**OXFORDSHIRE COUNTY COUNCIL'S RESPONSE TO CONSULTATION ON THE  
FOLLOWING DEVELOPMENT PROPOSAL**

**Application no:** 14/01830/REM

**Proposal:** Reserved matter – (Outline application 05/01337/OUT) – Details for the proposed sports changing pavilion adjacent to the sports pitches, including 29 associated car parking spaces and 2 coaches bays.

**Location:** Sport Pavilion land off Bankside Adjacent Longford Park Road, Bodicote

Rear Elevation

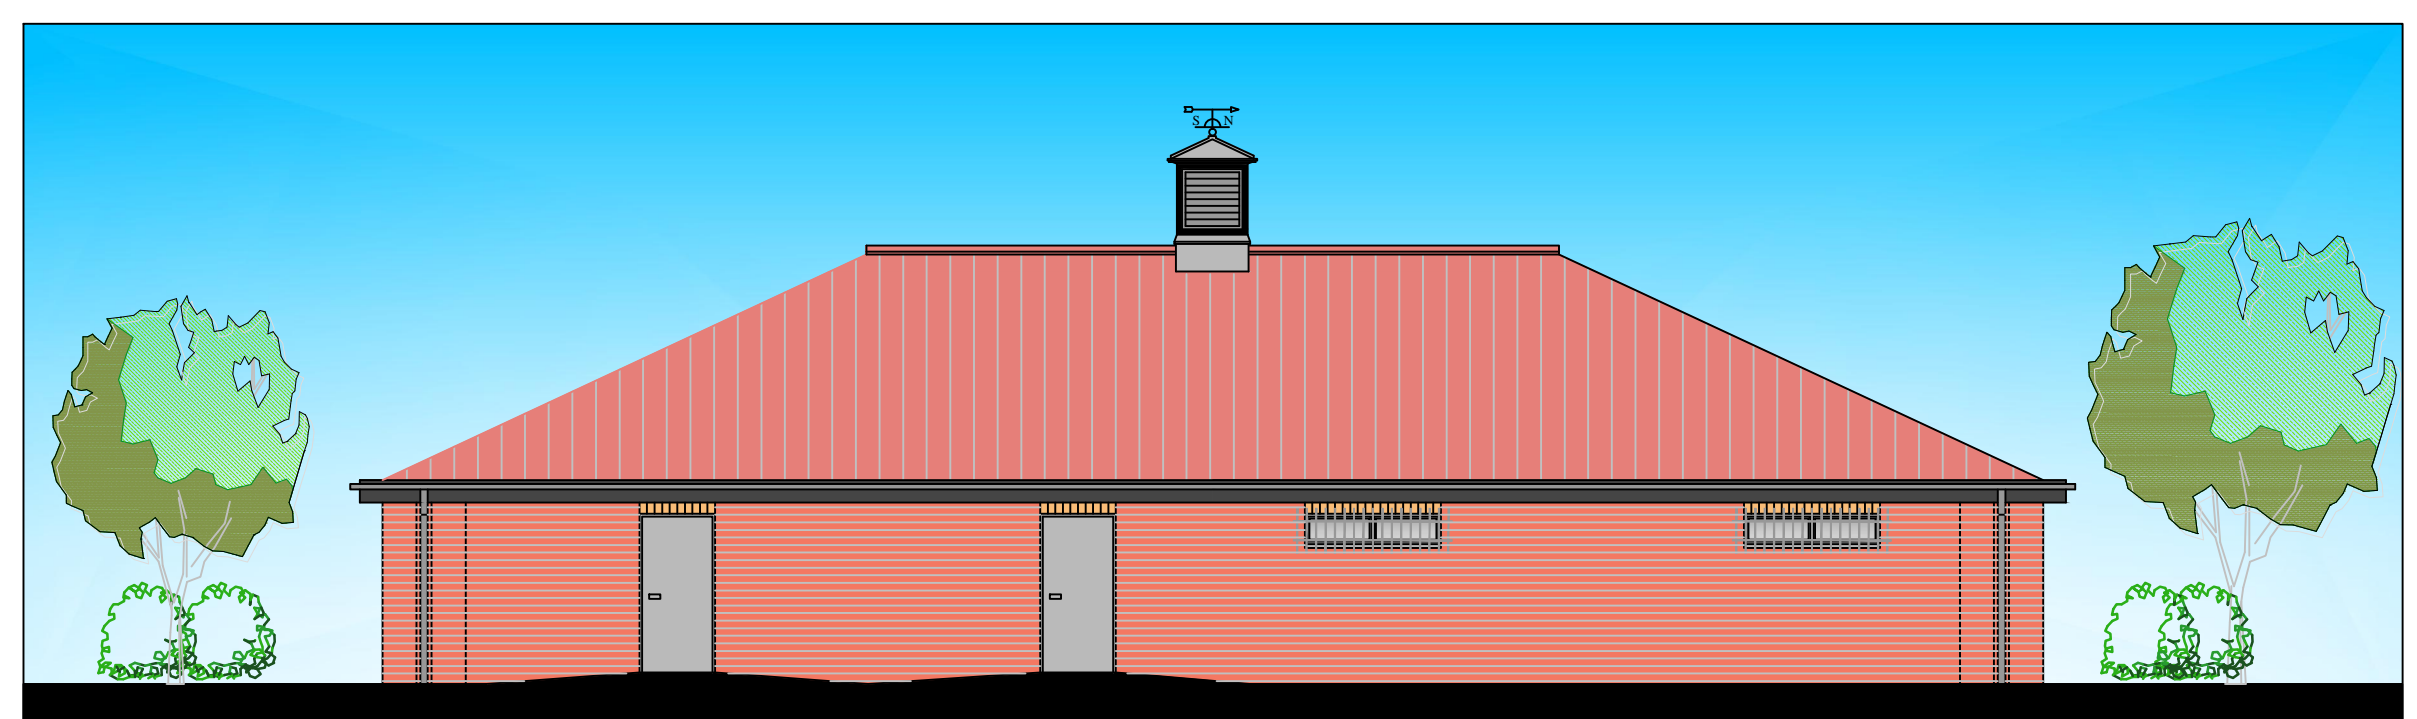
- No Cycle parking has been demonstrated on the supplied plans; this will need to comply with standards in terms of number of spaces, covered/secure, located as close to the main entrance to the building as possible and use 'Sheffield' type cycle stands.
- The Highway Authority has concerns regarding the proposed coach parking arrangement and there is likely access/egress issues – vehicle tracking will need to be supplied
- No refuse storage has been demonstrated, furthermore refuse vehicle tracking will need to be submitted
